Your Ref: MP 09_0187 MOD 3

MODIFICATION REQUEST – SECTION 75W MODIFICATION TO MIXED USE DEVELOPMENT AT 6-16 ATCHISON ST, ST LEONARDS (MO-09_0187 MOD 3)

I refer to your letter dated 2 June 2014 concerning the above matter. The proposed modifications have been reviewed by Council Planners and are not supported the reasons set out below.

0 5 12.5 25m
1 : 500 @ A3

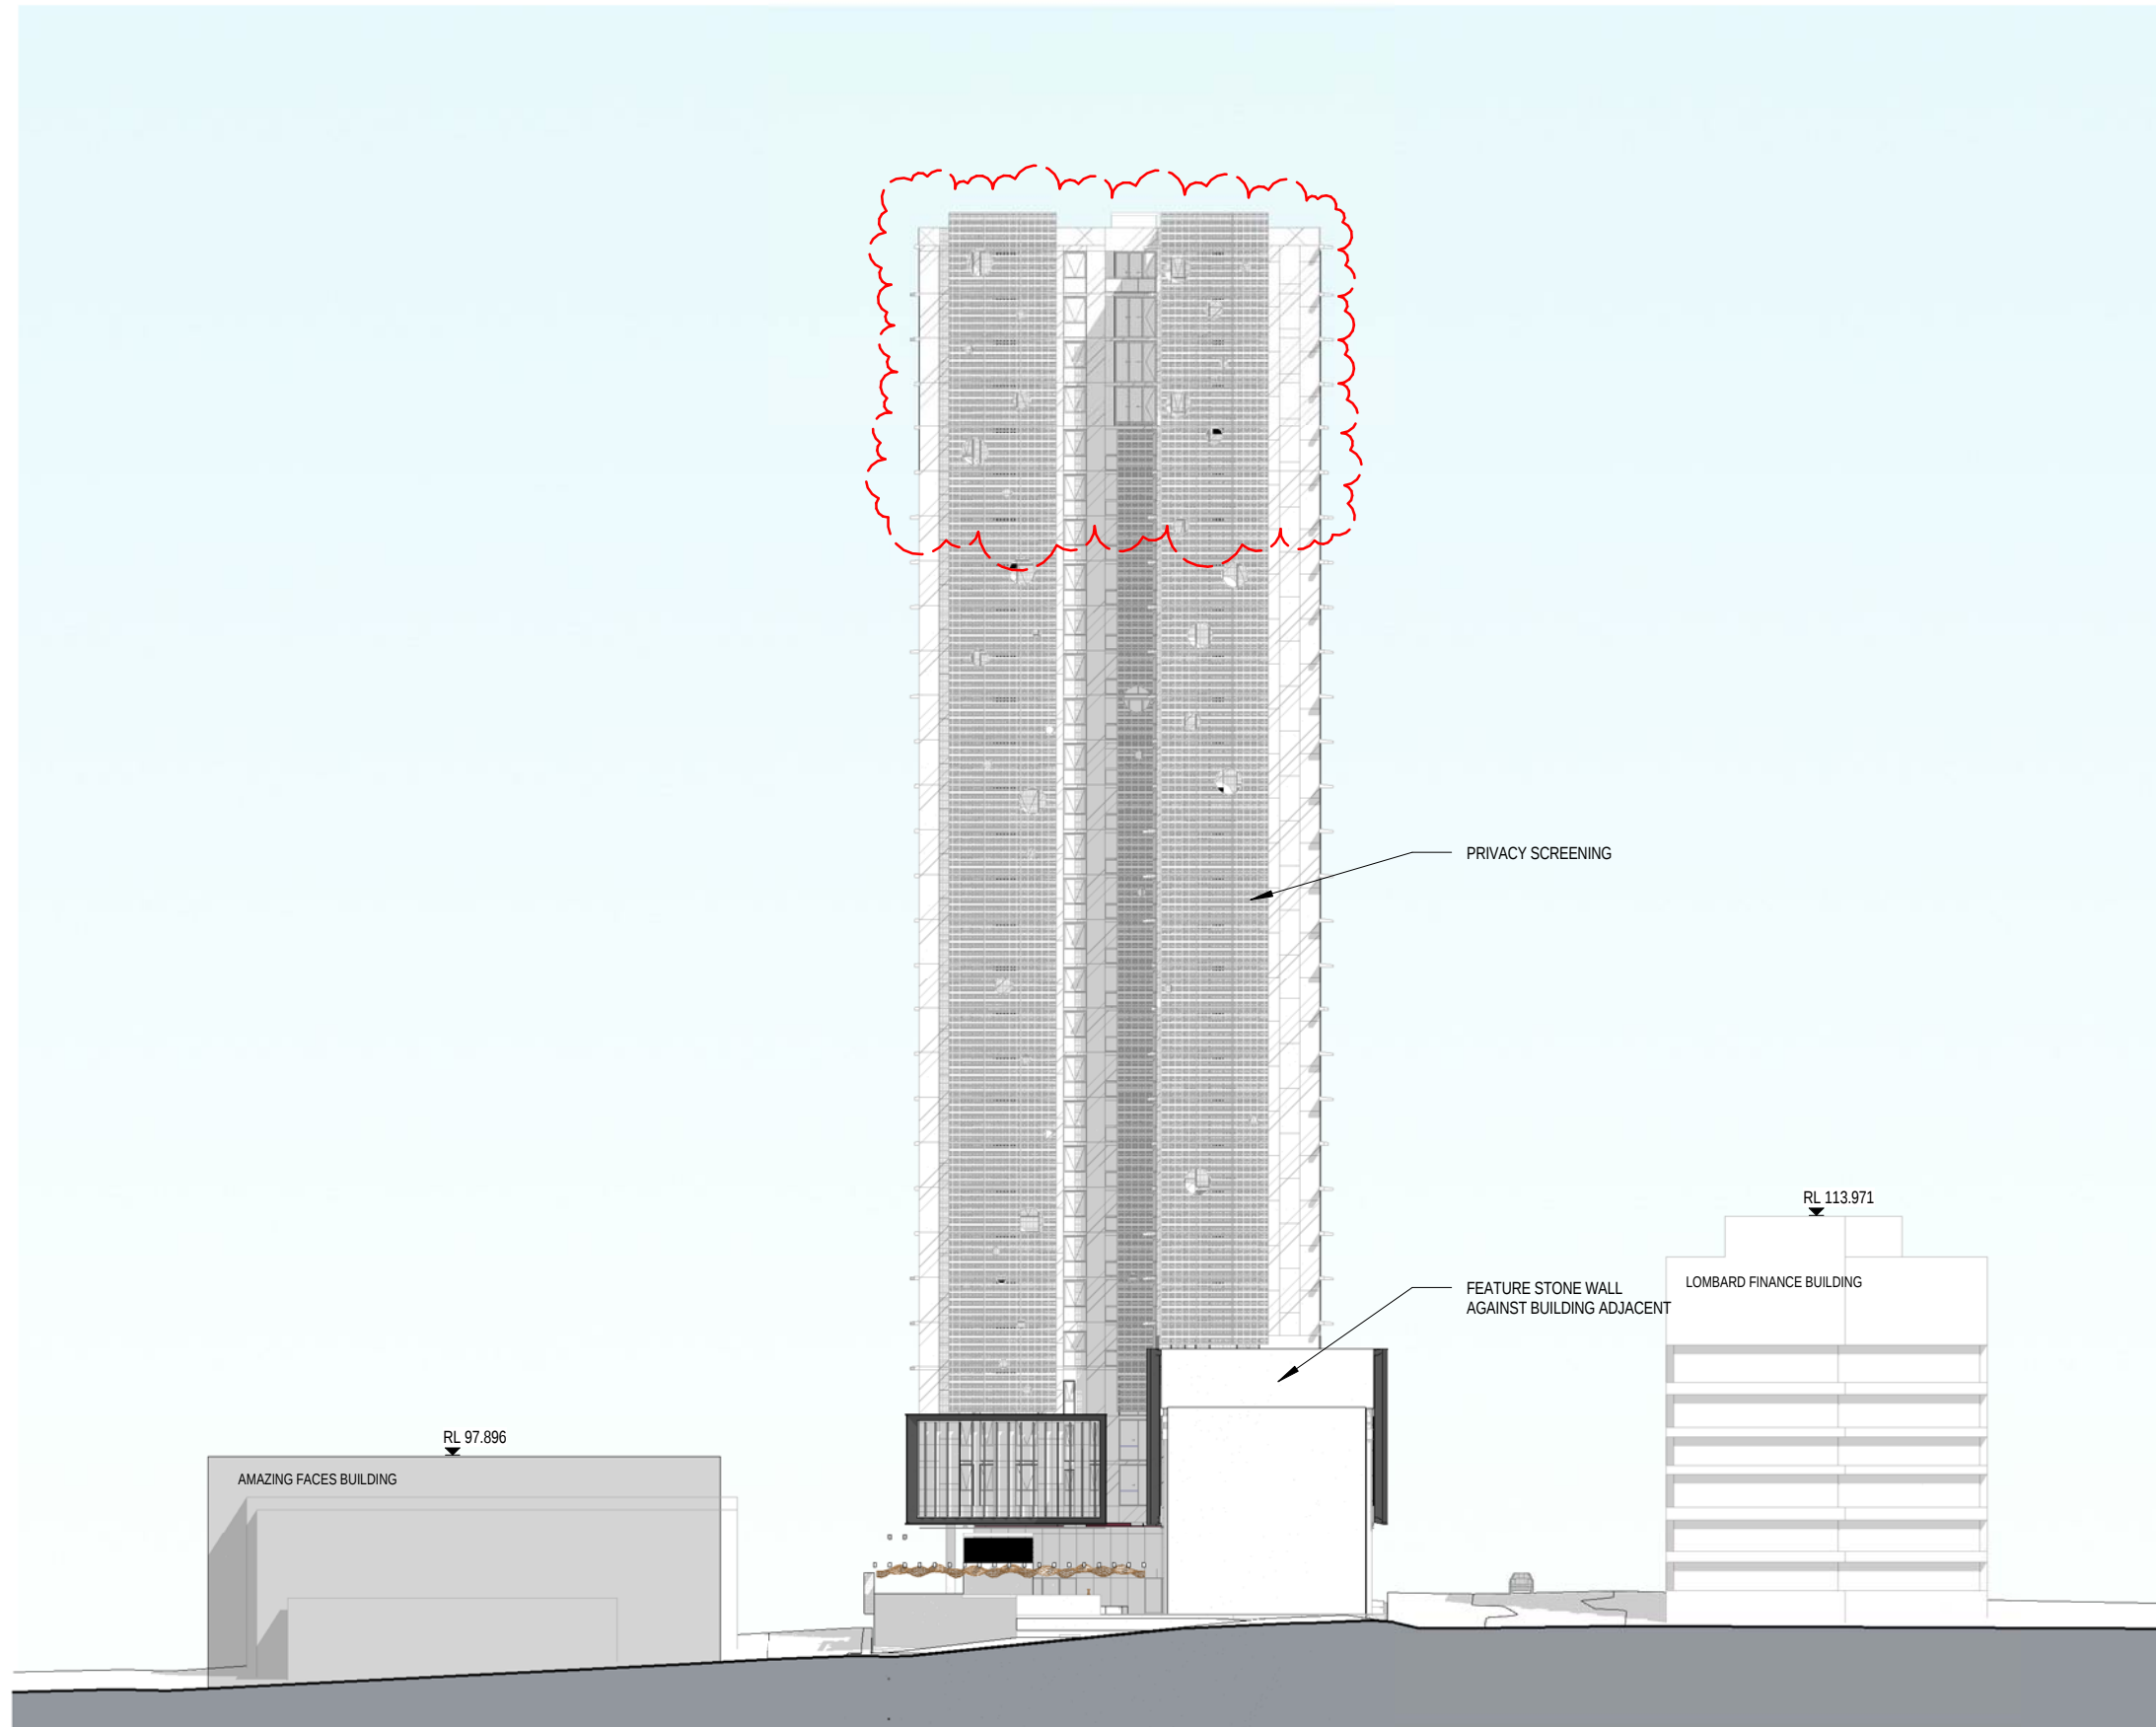
The proposed additional building height to be increased from RL167.3m (82.5m) to RL 181.3m (94m) AHD is strongly opposed. The North Sydney LEP 2013 sets a maximum Building Height of 49m on the site. Council strongly opposed the approved building height and form at the time. The proposed modification is seeking to reinstate an additional 4 levels that were previously refused by the Planning and Assessment Commission as part of the original development consent. This additional height continues to be without merit and should not be supported. The approval as it stands is considered to have compromised the orderly development of land in St Leonards.

The proposal fails to provide a clear understanding of the proposed height in relation to the local context. Tables comparing the proposal to other buildings combine data in storeys, RLs and metres which does not provide an accurate assessment of the proposed height against the local context, including The Forum. Similarly, the section diagrams are schematic at best.
